ADC PARKS & GREENSPACE ARBORICULTURE

PLANNING APPLICATION: A/23/15/OUT

ADDRESS: Land south of New Road (A259) and East of Brook Lane
Angmering N/A

BRIEF DESCRIPTION: Hybrid application - Full Planning Permission for a retail unit (Class A1) comprising 1,487sqm (1022sqm ground floor and 465sqm mezzanine) with associated access, car parking, servicing, landscaping & associated works.

Drawing Number C117420-02-01 Revision 00

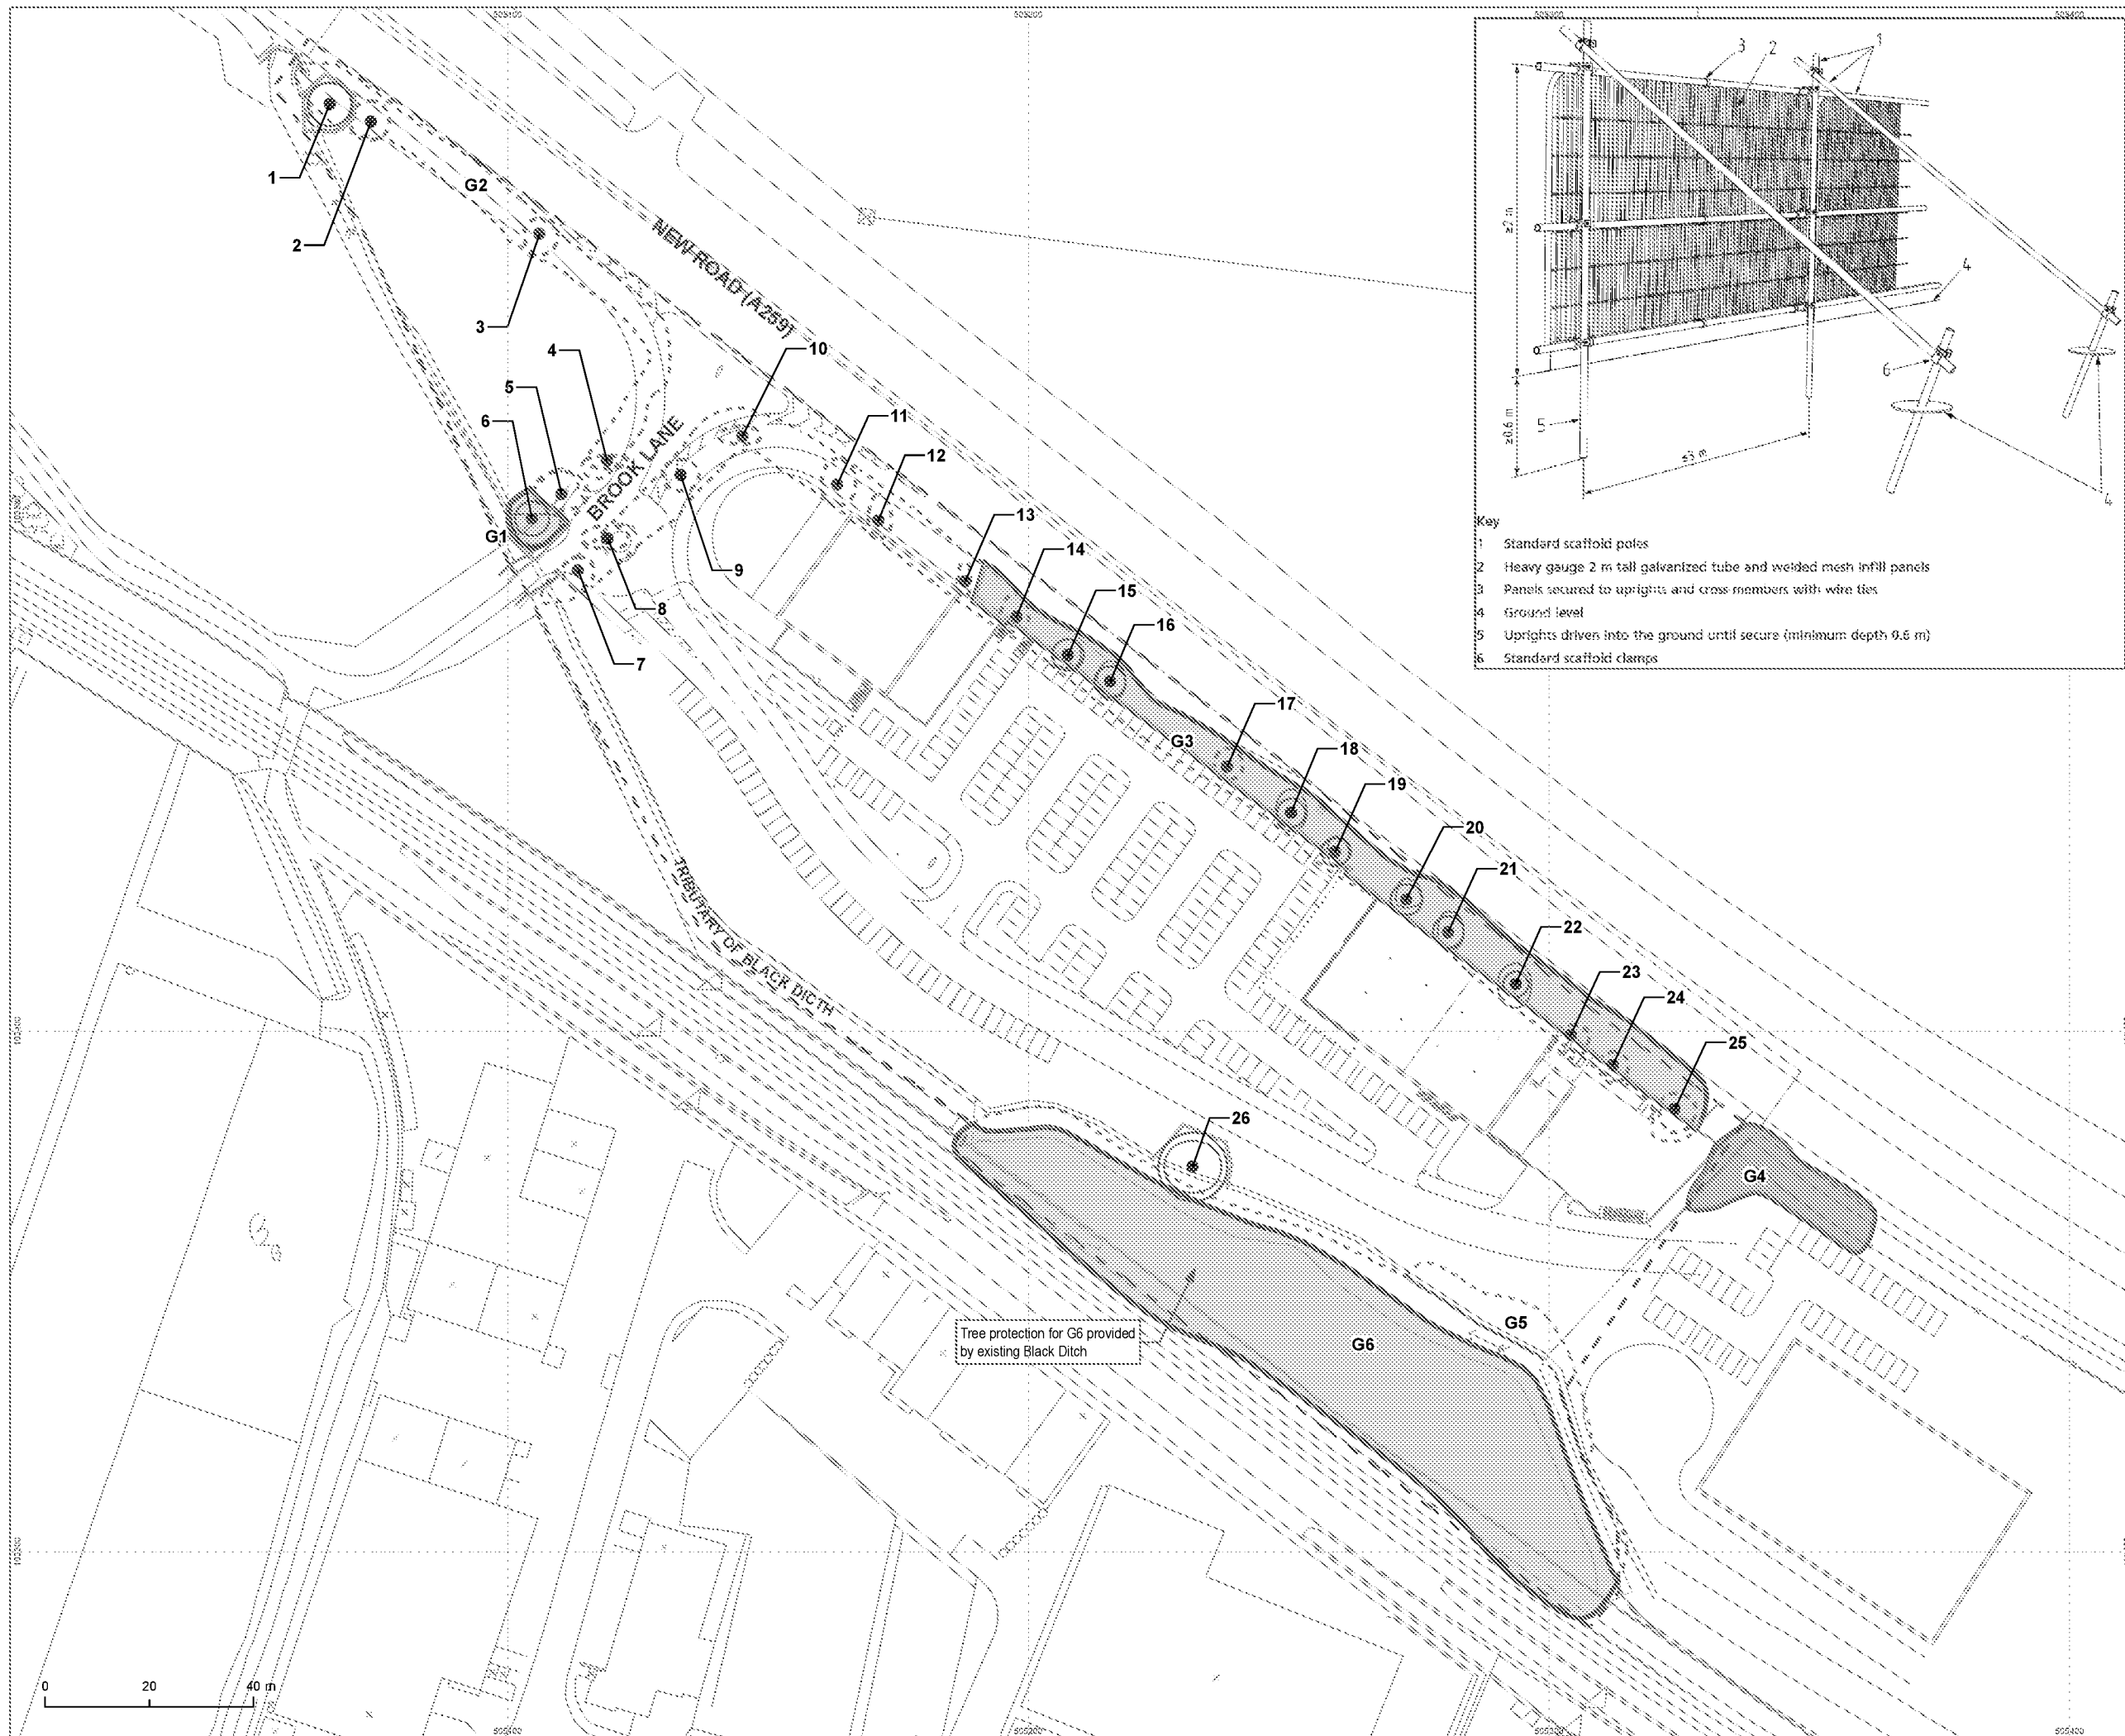
- The applicant has correctly recorded the trees that may be affected by the proposed development process.
- The applicant has identified **T2, T3, T4, T5, T7, T8, T9, T10, T11, T12, T13, T14, T17, T23, T24, T25**, all of **G1**, all of **G2**, part of **G3, G5** and part of **G6**, for removal. These trees were assessed when I completed the site visit. I would have no objection to the removal of these trees, as the trees in question did not have the features to warrant a TPO order/s.

- The applicant has cited the correct method and use of ground protective barriers (to protect the retained trees) and exclusion zones sizes that would meet the criteria set out in the BS 5837:2012. The applicant has also indicated access into the exclusion zones is required to complete soft landscaping. The method offered in working in these areas would meet the BS 5837:2012 standard.

- The applicant has produced the methodology a Tree Survey & Constraints Plan, Tree Retentions and Removals Plan, and Tree Protection Plan that meets the criteria outlined by the BS 5837:2012.
- As long as the methodology outlined in the application is adhered to, **I would therefore have no objection to the proposed development of this site.**
